An
Bord
Pleanála

Inspector's Report ABP-312927-22

Whether certain specified works of repair to the exterior of The Ambassador Theatre, a protected structure, are development and, if so, whether they are exempted development?

The Ambassador Theatre, Parnell Street, Dublin 1.

Figure 2a. Coade Stone decorative frieze to the rotunda theatre showing Bucranium and roundel.

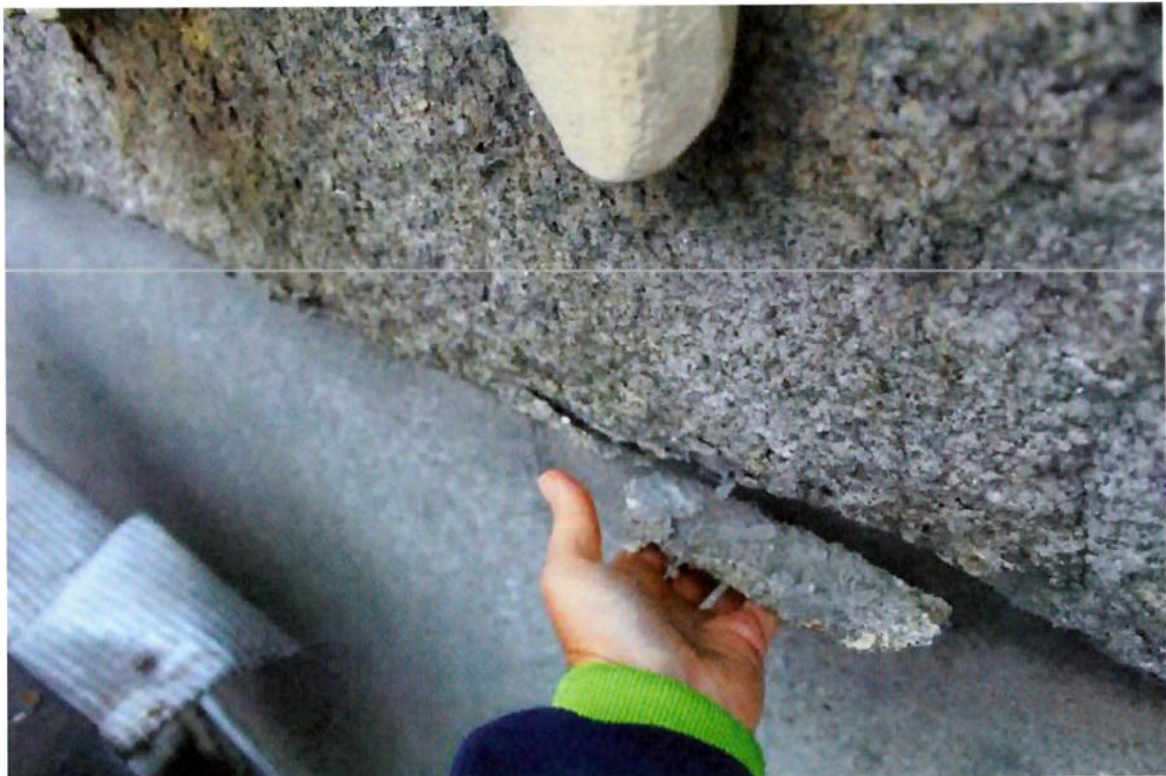
- 8.3.6. The referrer's Condition Assessment addresses the use of Coade stone in a decorative frieze that adorns the upper surface of the walls to the rotunda of the Ambassador Theatre. This frieze is composed of the following fixtures: 23 Bucranium (ox skulls) and accompanying swags and 25 roundels. Approximately 6 of these fixtures have previously been replaced and other repairs have included the use of cement mortar with mixed results. Portions of the swags and individual roundels are missing.

- 8.3.7. The referrer recommends repairs "under the direction" of Stoneware Restoration Ltd, a specialist firm that manufactures Coade stone to its original recipe. These repairs would entail the securing of loose fixtures with stainless steel fixings, the replacement of defective cement mortar, and the replacement of missing elements of the fixtures. (The applicant has retained the moulds for these fixtures from previous replacements and so they would be reused).

- 8.3.8. The backdrop to the decorative frieze is composed of courses of ashlar granite with accompanying joints filled with cement mortar. The referrer recommends that these joints should be raked out and repointed with a lime mortar. The referrer also recommends that, where the granite cornice has deteriorated above the decorative frieze, it either be replaced or stone indents be inserted. Likewise, where the granite edge to the bottom of the frieze has become friable that it be removed. It thereby envisages that the backdrop to the decorative frieze would be stabilised.

- 8.3.9. The Planning Authority emphasises the importance of the decorative frieze, as the only one of its kind in Ireland, and as one of the best examples of the use of Coade stone anywhere. It expresses concern that the applicant's assessment and recommendations are too general and so insufficient detail of the proposed repair works has been submitted. Consequently, these works would, potentially, materially affect the character of the protected structure.

programme nor any methodologies for the protection of sensitive items, such as the Coade fixtures, has been submitted. Given the overlapping nature of the proposed works to the decorative frieze, such a programme and methodologies are important if the referrer is to demonstrate that the proposed works would be capable of being carried out without materially affecting the character of the protected structure.

Figure 15 Arcade link to the Rotunda Hospital with the Rotunda Theatre building behind. Left had side was subject to a cleaning trial by Thomann-Harry. This has proved to be too severe and we do not recommend using it.

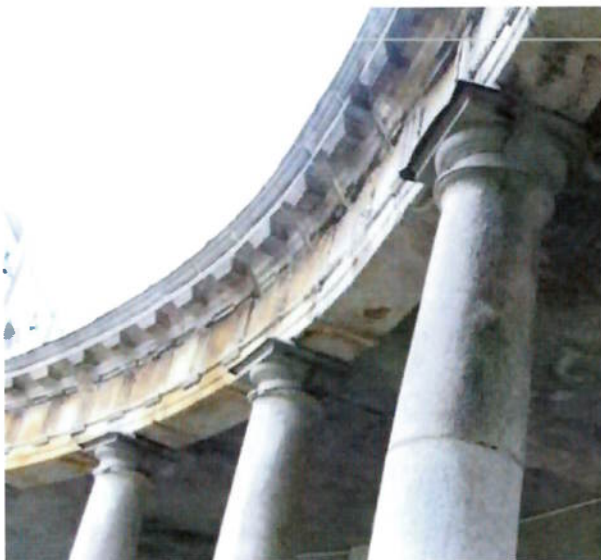
8.3.3. The referrer's Condition Assessment identifies cracking to granite soffits in the front (west) arcade to the Ambassador Theatre. It also identifies extended horizontal cracking to the render in the Theatre's east elevation, both to the ashlar effect render on the wall and the upper surface of the rendered cornice above this wall. The referrer's recommendations do not address these cracks as it is acknowledged that their cause remains unknown and so the referrer proposes that they be the subject of investigation by a conservation structural engineer.

8.3.4. The Planning Authority cites the Architectural Heritage Protection Guidelines, which advise that works should be "based on a proper knowledge and understanding of the existing structure." Dissatisfaction is expressed over this lacuna in the referrer's proposed works.

8.3.5. Clearly, in the absence of a known cause for the cited cracks, no repair works can be proposed with any confidence and so the referrer is not in a position to demonstrate that such works would not materially affect the character of the protected structure.

Front Elevation
SCALE 1/100

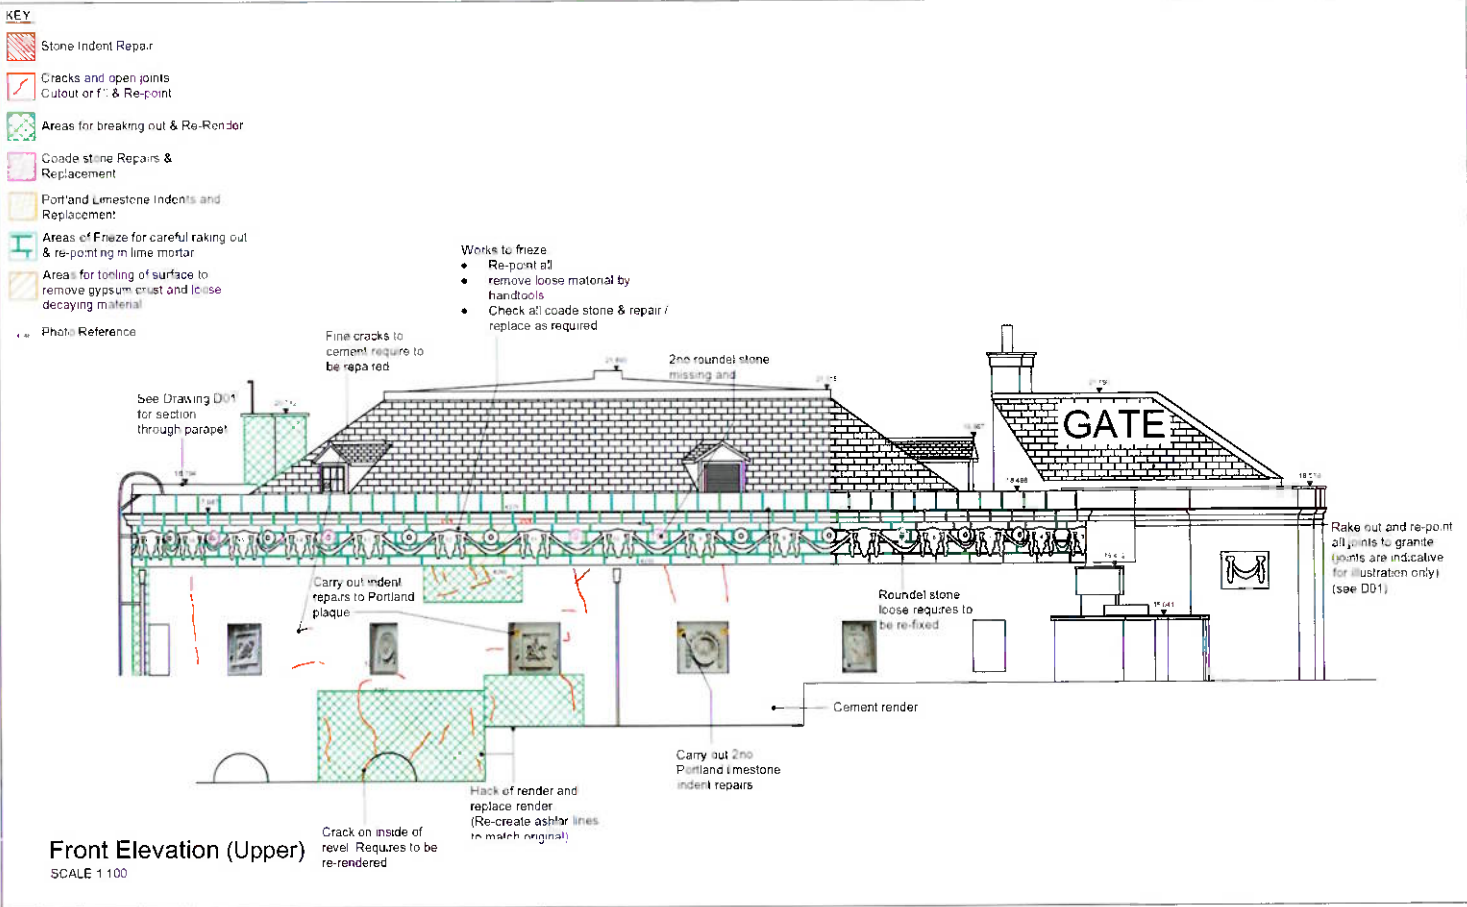
- Removal and re-application of lime render from the blind arch on the (western) return elevation to the front portion of the building. This arch abuts the roof to the arcade (cf. Drawing No. L05 and Figure 16 of the referrer's Photographs (Appendix C)),
- Patch cement render to the old cement render on the rotunda walls below the decorative frieze and re-render chimney in its entirety (cf. Drawing No. L05), and
- Patch repairs to cracking and detaching cement render with added mica on the eastern elevation (cf. Drawing No. L02).

8.3.17. The Planning Authority expresses concern that the above cited repairs have the potential for visual discord between retained and new areas of render resulting in a patchwork appearance to the affected elevations.

8.3.20. I note that the referrer recognises that it is not possible “ahead of time” to be precise as to the exact mix of mortars that would be appropriate to ensure that patchwork appearance scenarios are avoided. It states that samples would be presented to the Planning Authority for approval. However, the formal opportunity for such submission and approval would only arise on foot of a planning condition, which presupposes the existence of a planning permission rather than a Section 5 declaration of exempted development. I note, too, that the proposed treatment of the rear elevation would affect its existing appearance. In both instances, the proposed works would, potentially, have a material affect on the character of the protected structure.
